CITY OF ALBUQUERQUE

January 7, 2015

**Re: The NM Vietnamese Buddhist Association
420 Pennsylvania SE
Conceptual Grading & Drainage Plan (L19D050)**

GRADING AND DRAINAGE PLAN

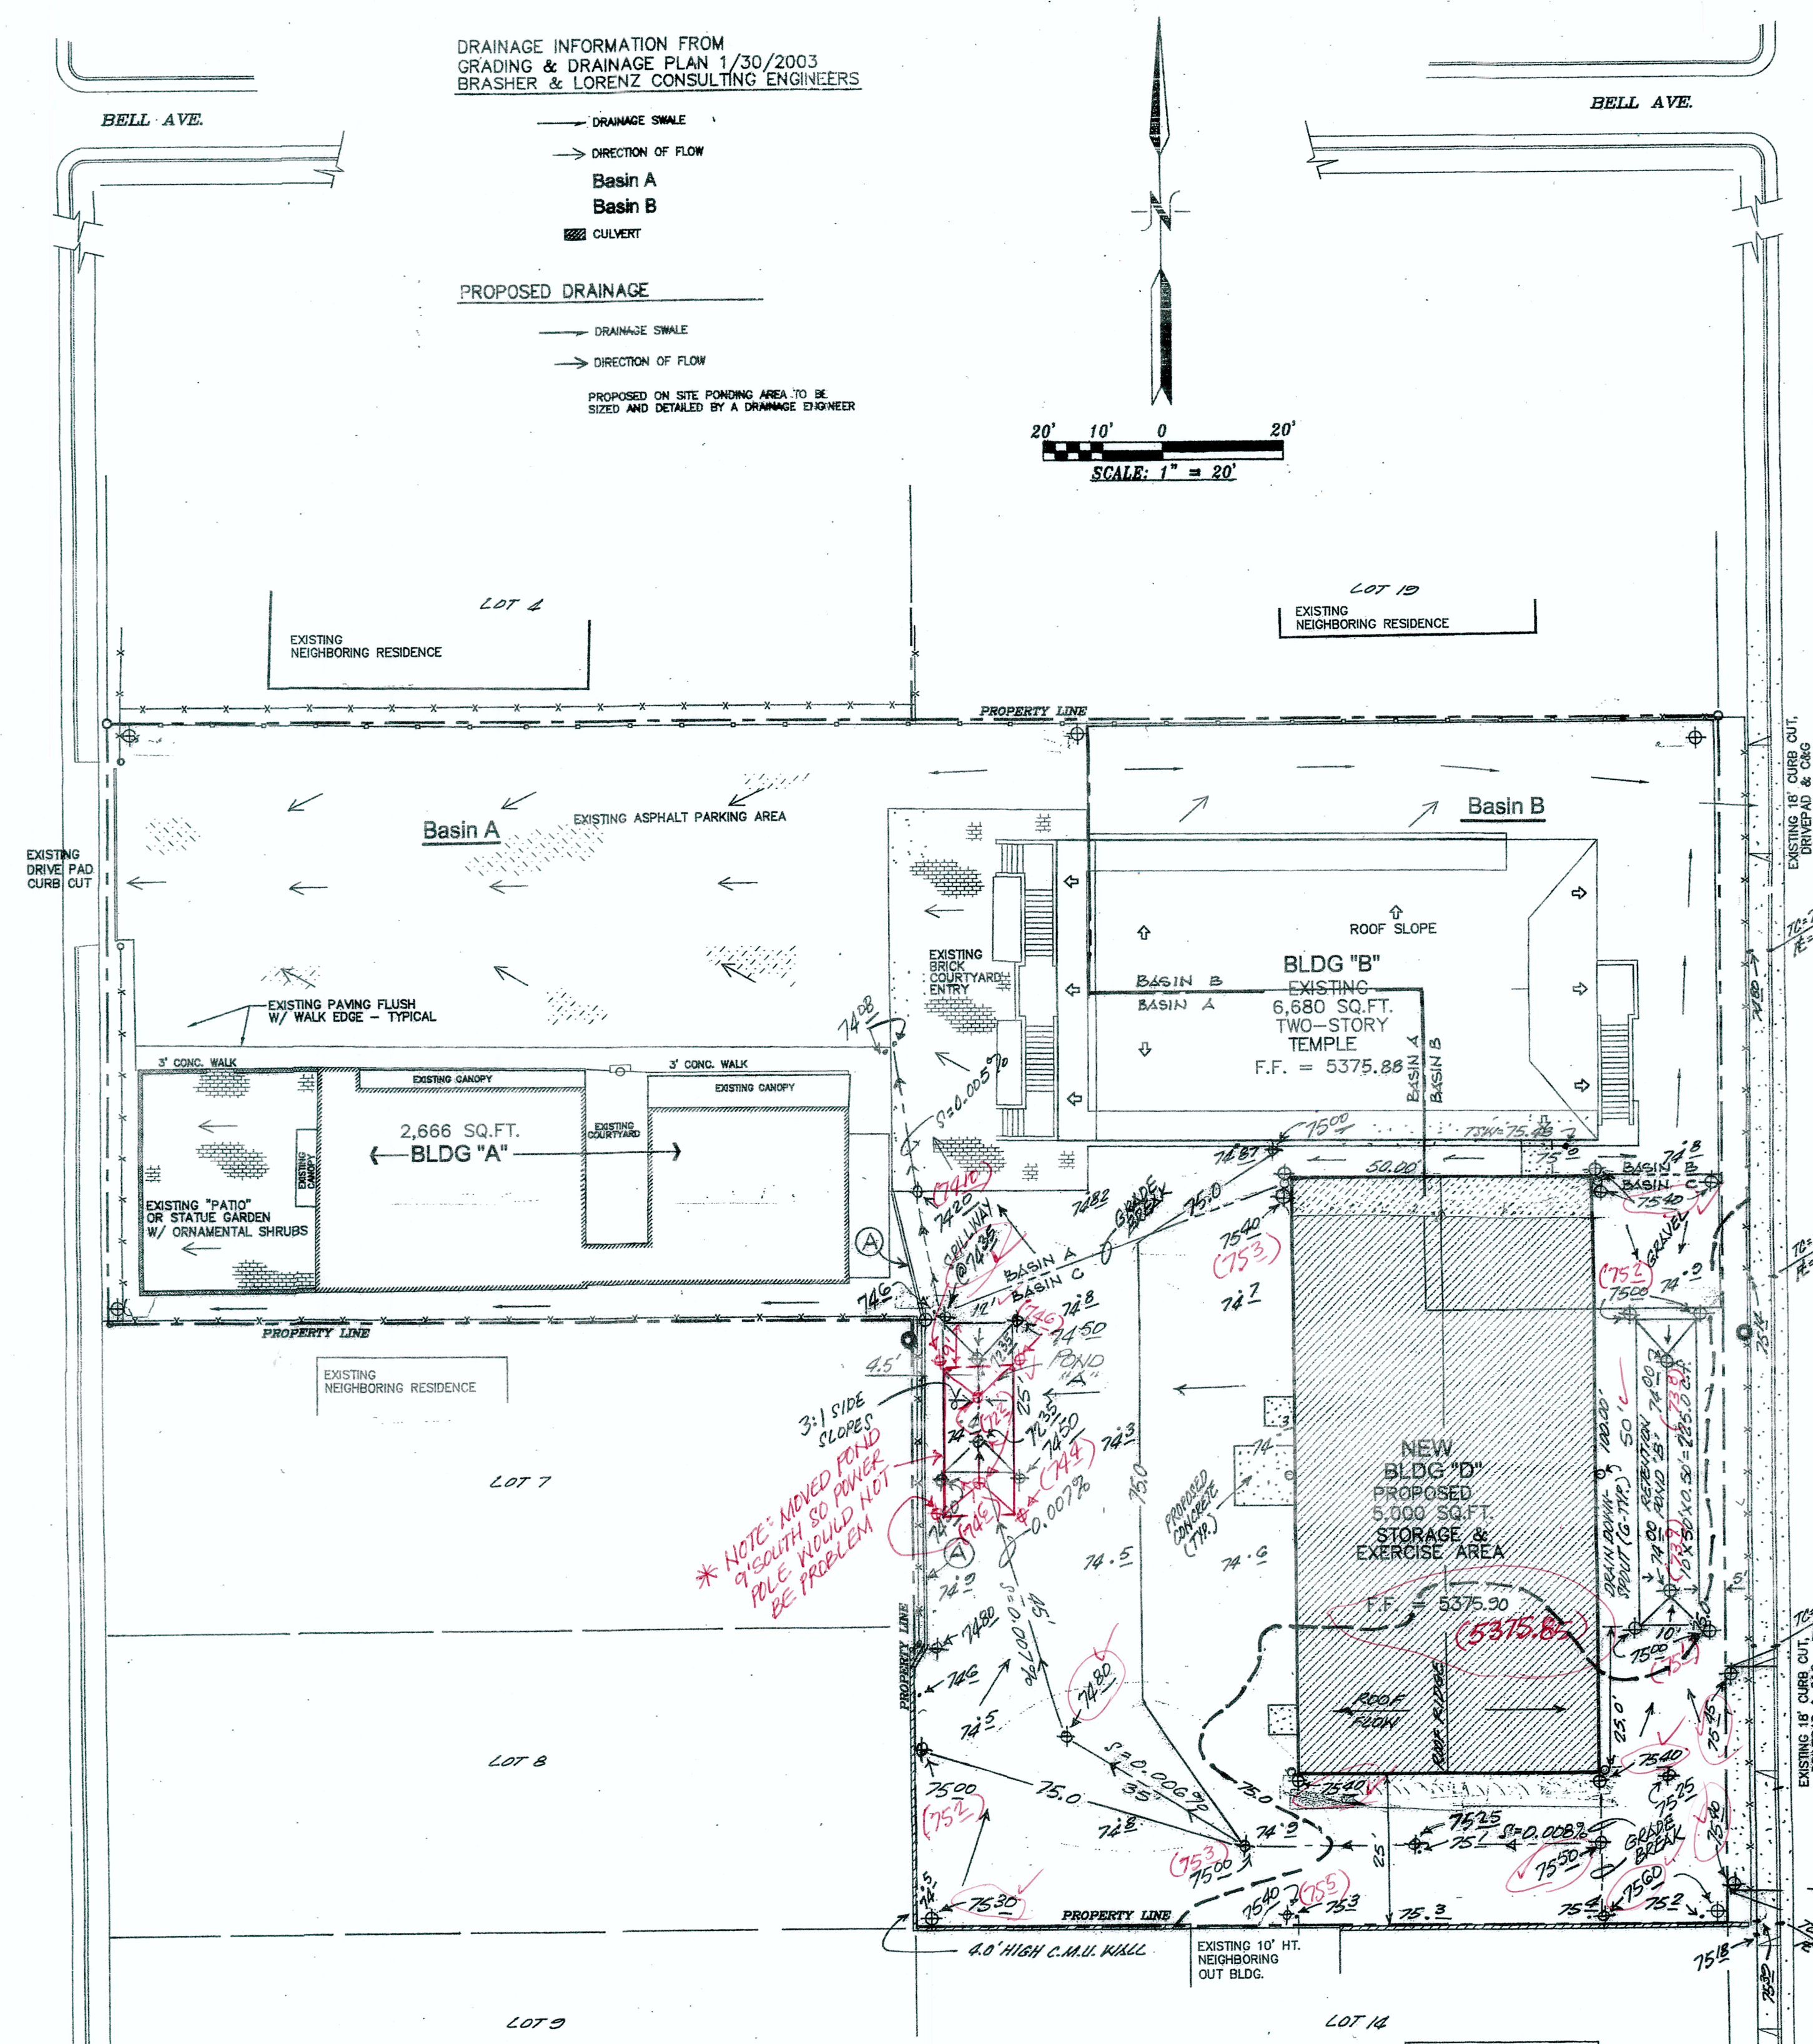
- The corner to the west of the building next to the adjacent property needs to be lowered from the 74.6 spot elevation.
- Show the pond spillway allowing the flows to leave the site to the north.
- A curb along the west property line needs to be added to direct the flows away from the adjacent property.

The pond shown will be fine for the management of the first flush.
